Application for a non-material amendment following a grant of planning permission.  
Town and Country Planning Act 1990

REM TO 13 | 00433 | OUT - SITING, DESIGN, EXTERNAL APPEARANCE, LANDSCAPING, LAP, INFRASTRUCTURE, POINTS OF ACCESS AND ASSOCIATED WORKS FOR 207 NEW DWELLINGS.

16 | 02482 | REM

SITE LAYOUT AMENDED TO ACCOMMODATE PLOT SUBSTITUTION OF 47 NO. PLOTS WITH 3 NO. HOUSE TYPES, NAMELY THE X414U, X309U AND X519 TO REPLACE THE RESPECTIVE APPROVED HOUSE TYPES J, G AND L.

HOUSE TYPE X9v PLANNING DRAWING  
 3 BED TWO AND HALF STOREY - BRICK  
 PROPOSED PLANS & ELEVATIONS  
 1:100 @ A3  
 KME\_02\_PD\_X309v 01

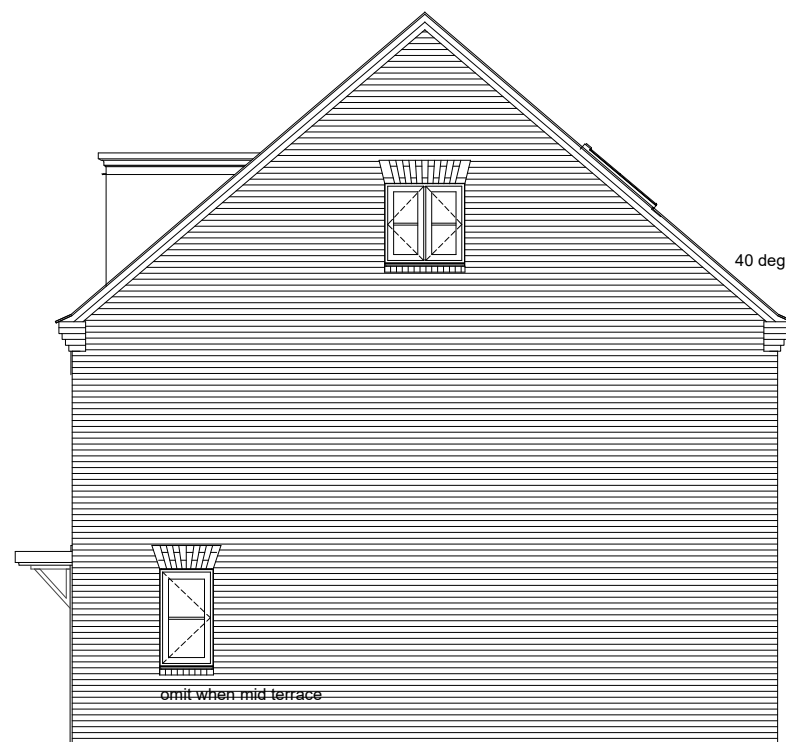
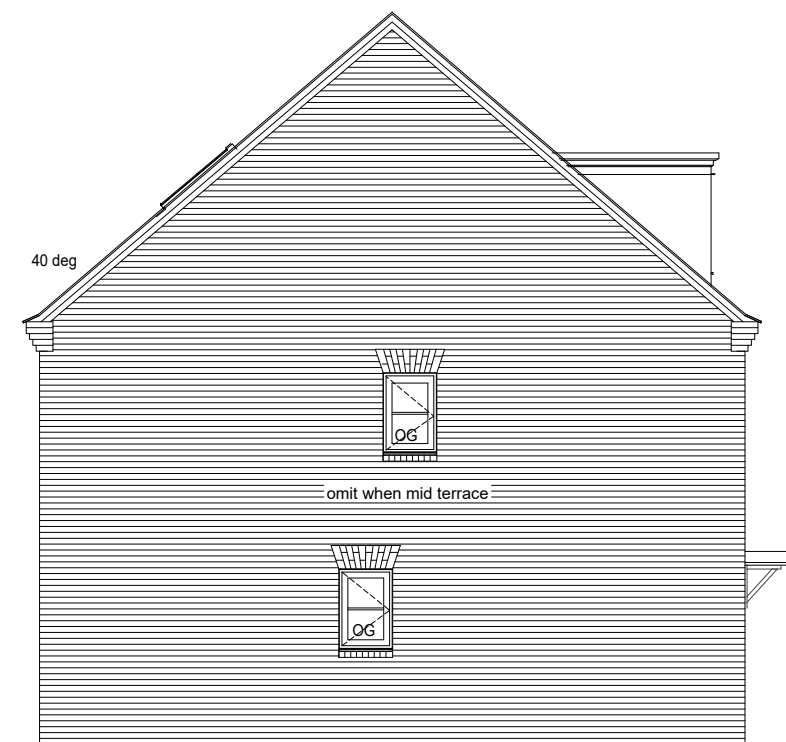
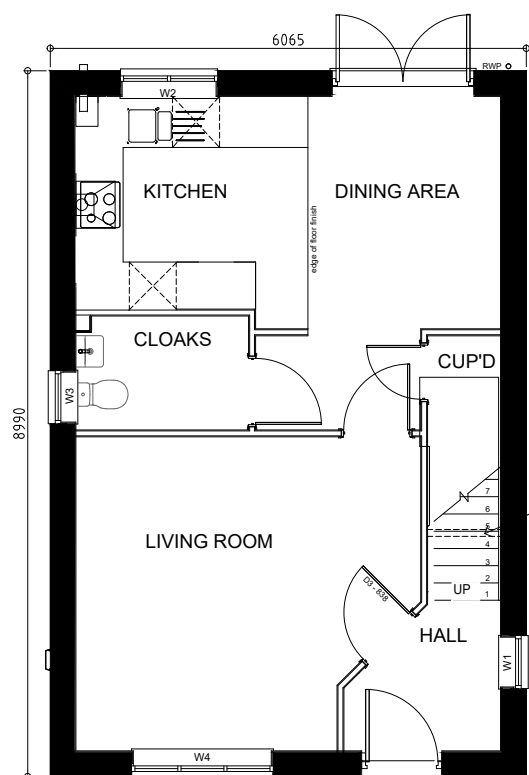
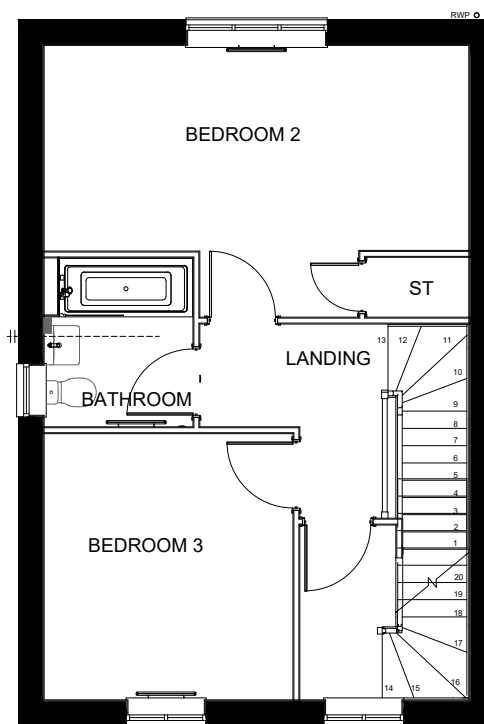
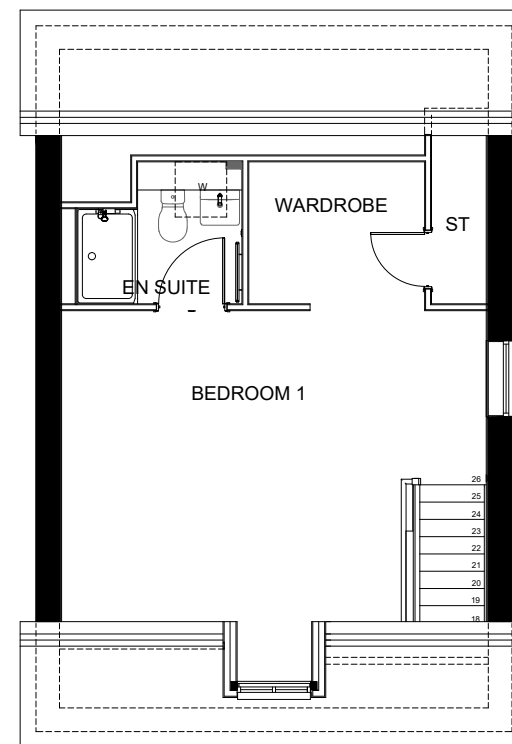
PLANNING LAYOUT: BKME-02-260 REV G, ~~HTPD~~; X519: KME-02-PD X519 01, 02 + 03.  
X414: BKME-02-PD-X414 01 + 02, X309U: BKME-02-PD-X309 01 + 02
